DeYOUNG SUBDIVISION Construction Drawings El Paso County, Colorado

PCD-ENGINEERING REVIEW COMMENTS
IN BLUE BOXES WITH BLUE TEXT

TITLE SHEET

PCD PROJECT NO. MS-20-001

SHEET: **C1.1**

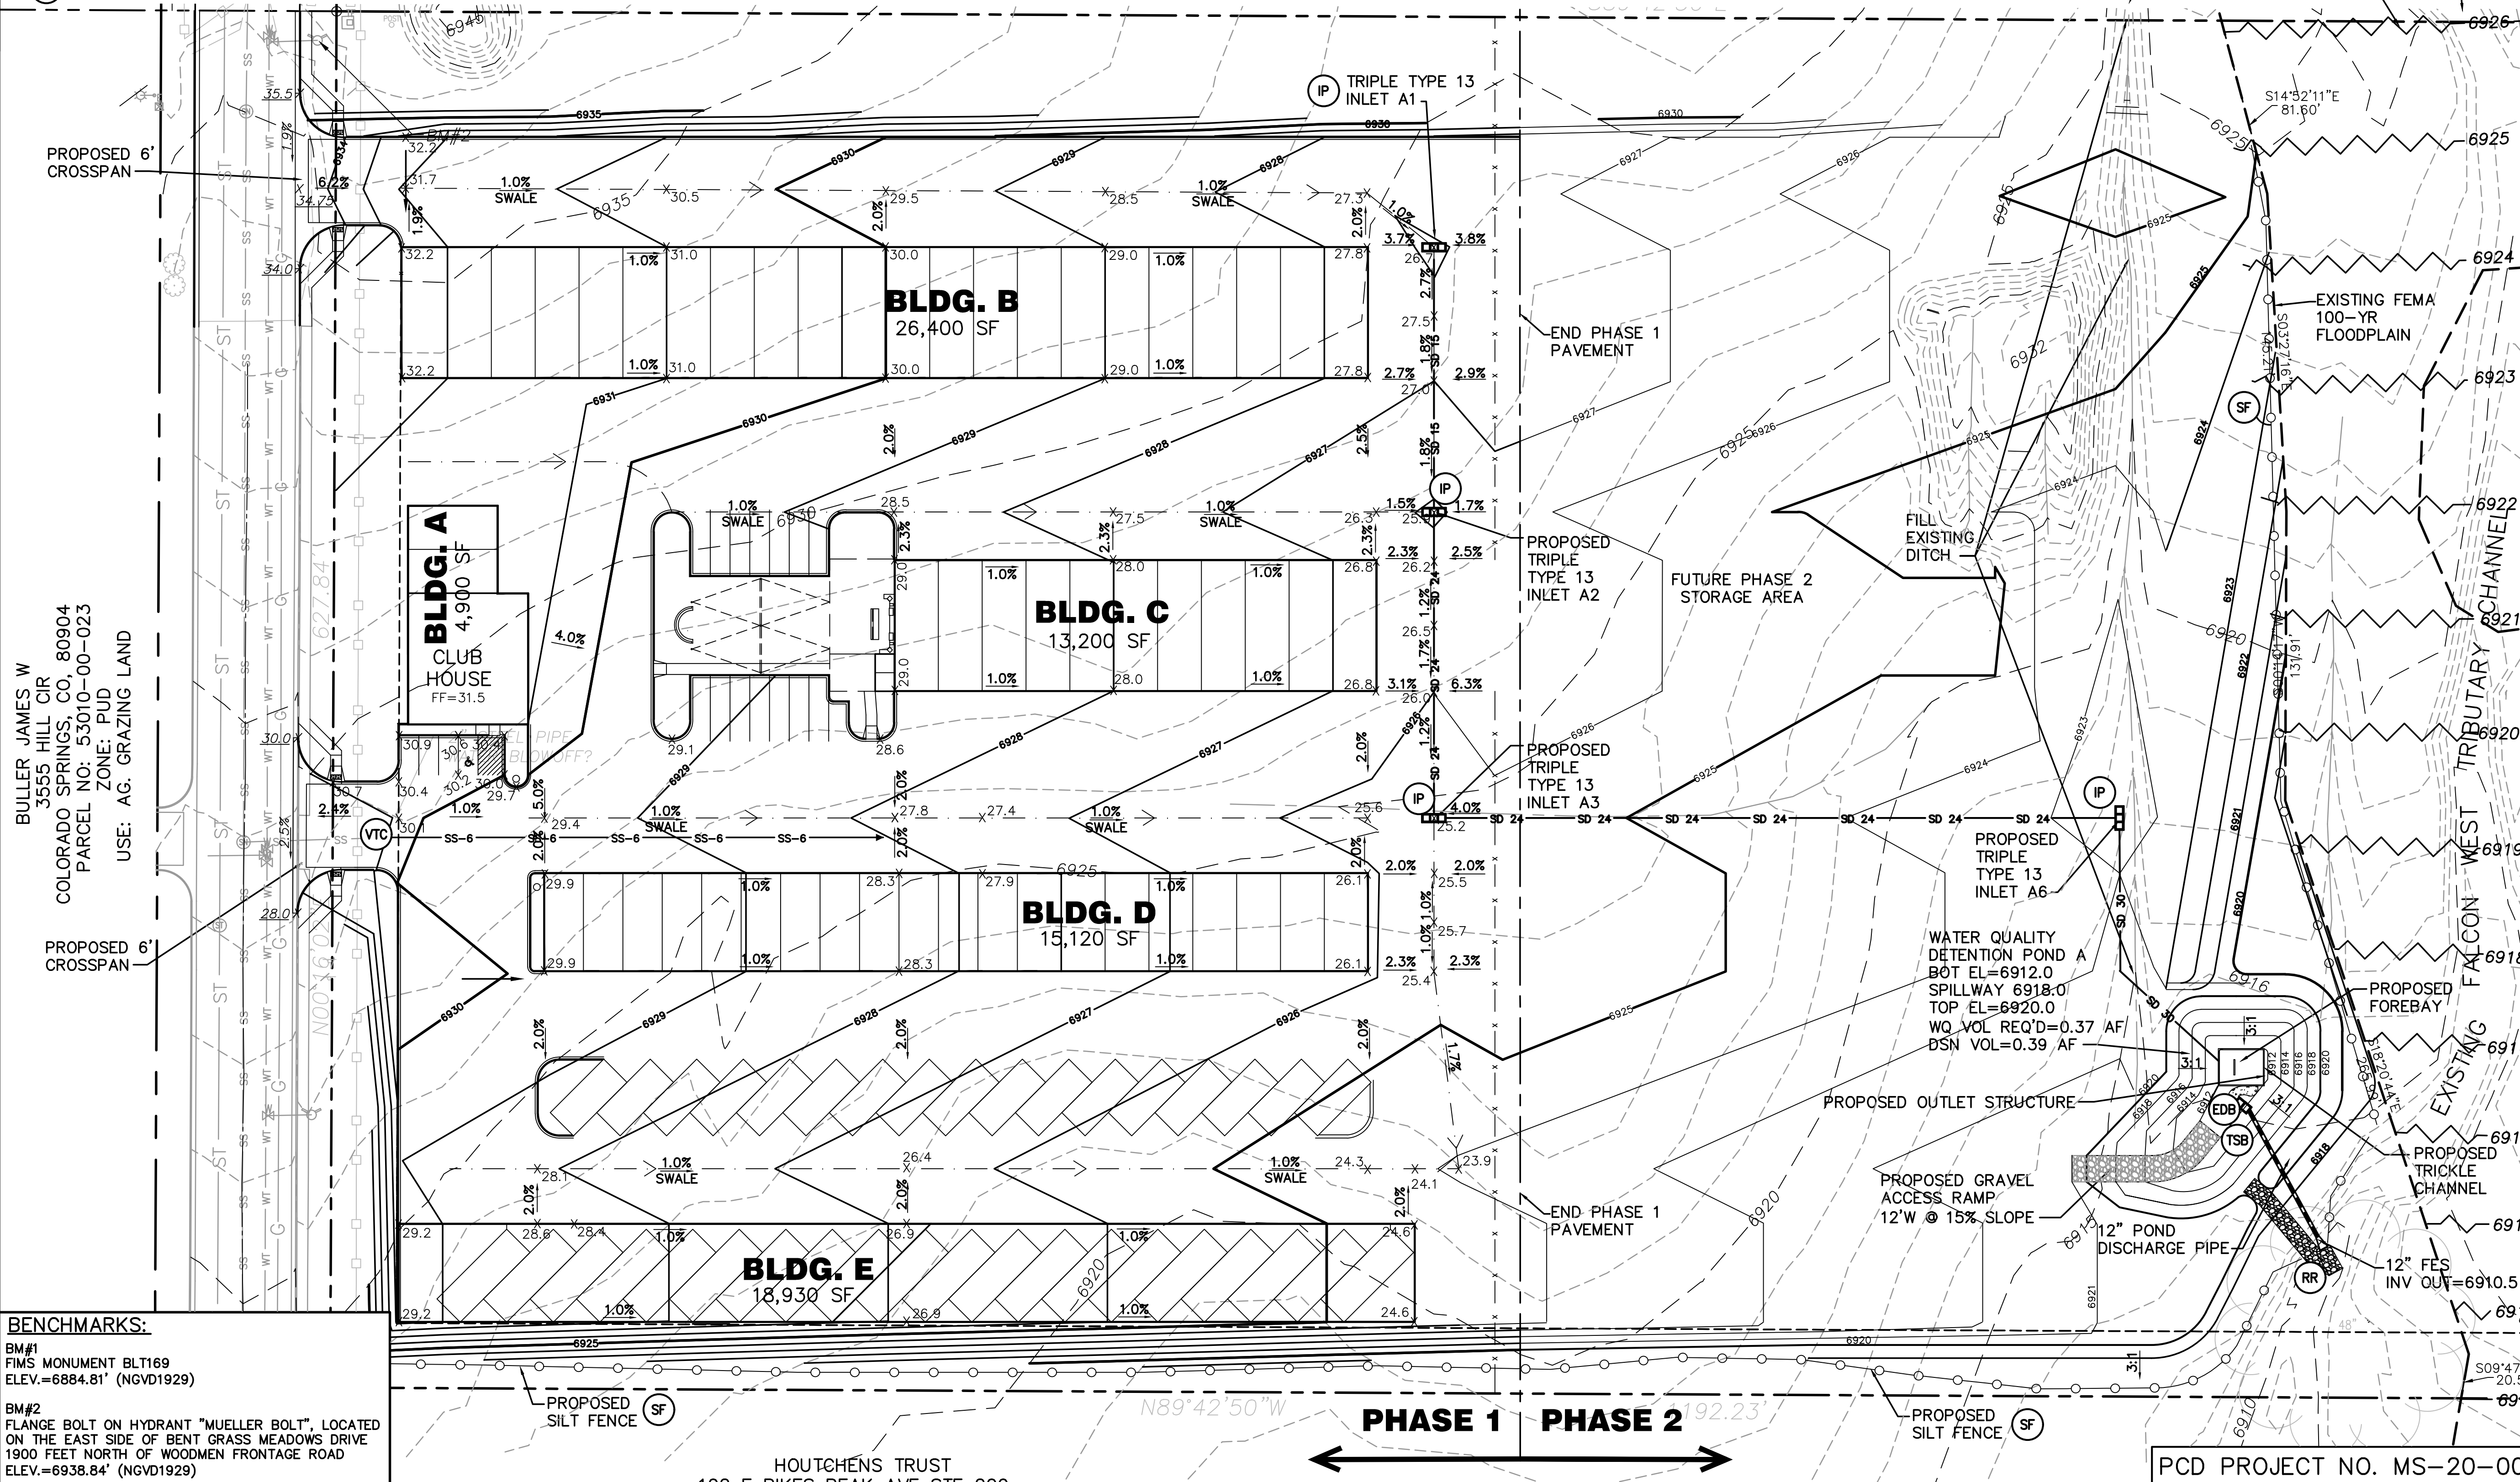
Is this a raised island?
 Don't show parking spaces
